KIRKLEES METROPOLITAN COUNCIL INVESTMENT & REGENERATION SERVICE

DELEGATED DECISION TO DETERMINE APPLICATIONS FOR CONSENT, AGREEMENT OR APPROVAL REQUIRED BY CONDITION

Reference No:	2026/44/91457/W
Site Address:	Bankgate Mills, Bank Gate, Slaithwaite, Huddersfield, HD7 5DL
Description:	Discharge of details reserved by conditions 3 (materials), 5 (archaeological and architectural recording), 12 (statement of works) on permission 2022/92459 for conversion of former mill to form 5 apartments including extension and alterations, demolition of outbuilding, construction of 4 open sided car port structures and associated works
Recommending Officer:	John Holmes

DECISION – Discharge of Conditions - Approved

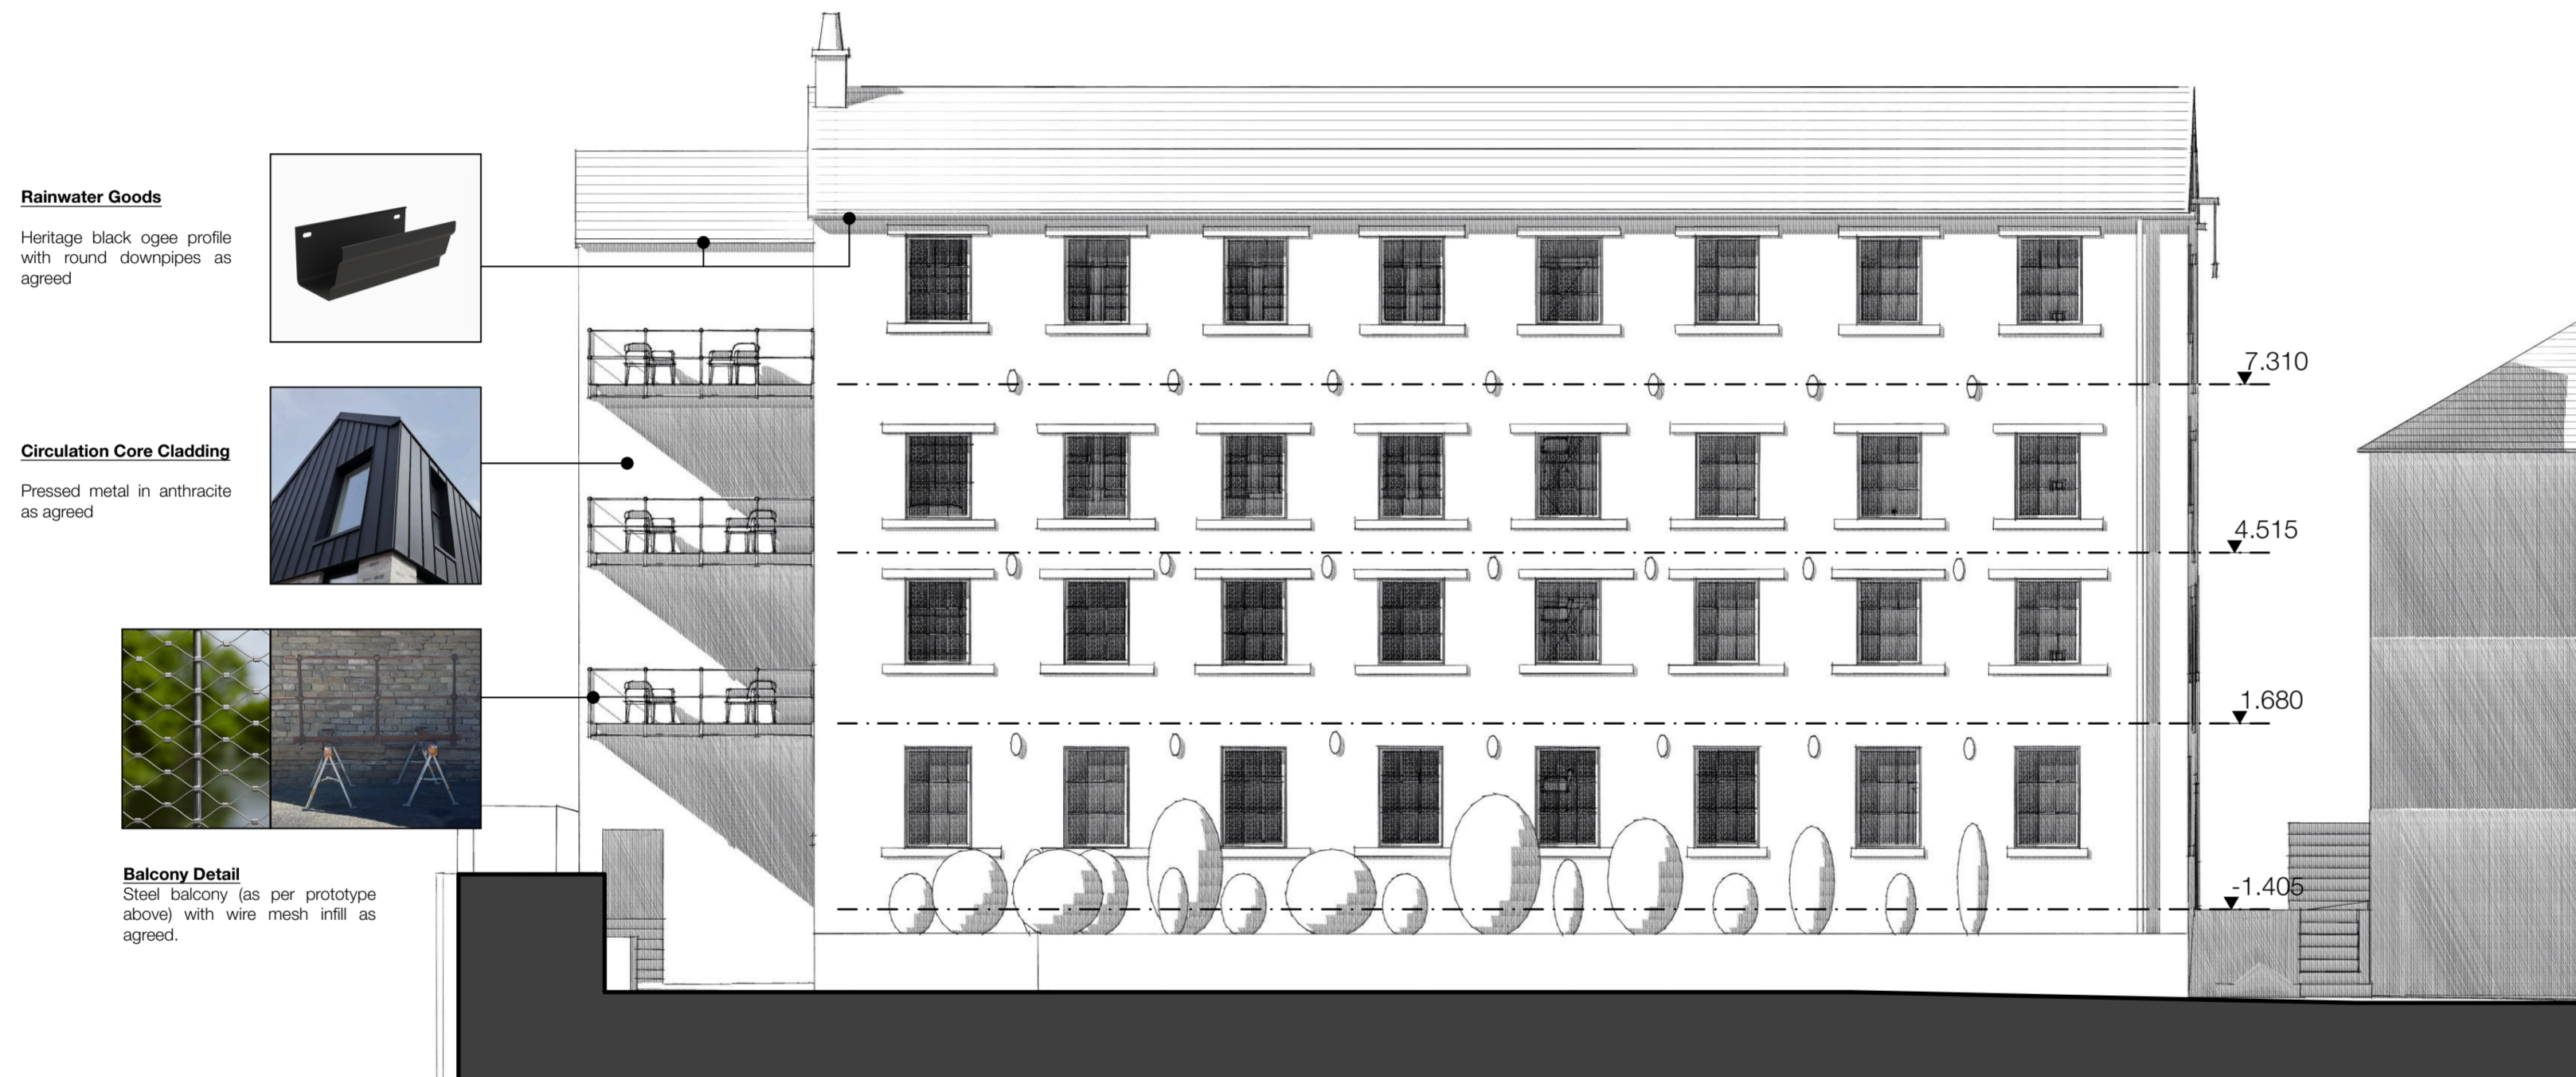
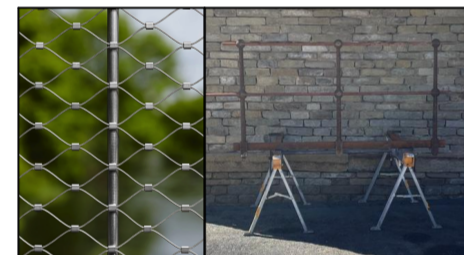
The submitted details set out in the submitted drawing includes Heritage black ogee profile with round downpipes for the gutters, pressed metal in anthracite to the external wall of the extension and steel balcony. Images of the proposed materials as set out in the drawing are provided.

The scheme as approved by permission 2022/92459 details that a carport structure and a gable roof extension to the building are approved. The roofing materials of the car port, and external materials for the supporting structure of the car port are not detailed in the submitted scheme. No details of doors or surfacing are provided, downpipes (or whether any are to be installed) is also not set out within drawing 3486 (SK) 25. The specific metal or colour finish (such as a RAL colour code) is also not set out in relation to the external cladding which is proposed to the extension.

- Balcony materials – steel balcony with wire mesh infill
- Circulation core cladding materials and colour finish – pressed metal in RAL 7015
- Car port details, materials and finishes – green oak timber frame and steel construction, natural blue slate roof, metal, ogee profile gutters, round downpipes in RAL 9005
- Solar panel details – integrated all black solar panels flush with roof
- Door materials and colour finish – salvage of existing timber doors to be painted in RAL 7030

- Window materials, profile and colour finish – Senior Aluminium New G Single Profile windows, double glazed comprising 4mm Softcoat Toughened Clear 1.2. 16mm Black Warm edge spacer, Argon Low E air space with 4mm Clear Planitherm One Toughened (24mm overall). Glazing pattern to match existing with all windows set back into reveals. Frames and glazing bars to be finished in RAL 7030.
- Roofing materials – re-use of original stone slate roof. Salvaged and reclaimed tiles should not be turned.
- Surfacing materials – limestone gravel
- Rainwater goods materials and colour finish – metal, ogee profile gutters, round downpipes in RAL 9005

As a result, further details were submitted which have been considered acceptable by the Council's Conservation and Team Team. The submitted scheme is considered to be acceptable and therefore this condition is recommended to be discharged on the basis of the listed details set out earlier in this section of the report.
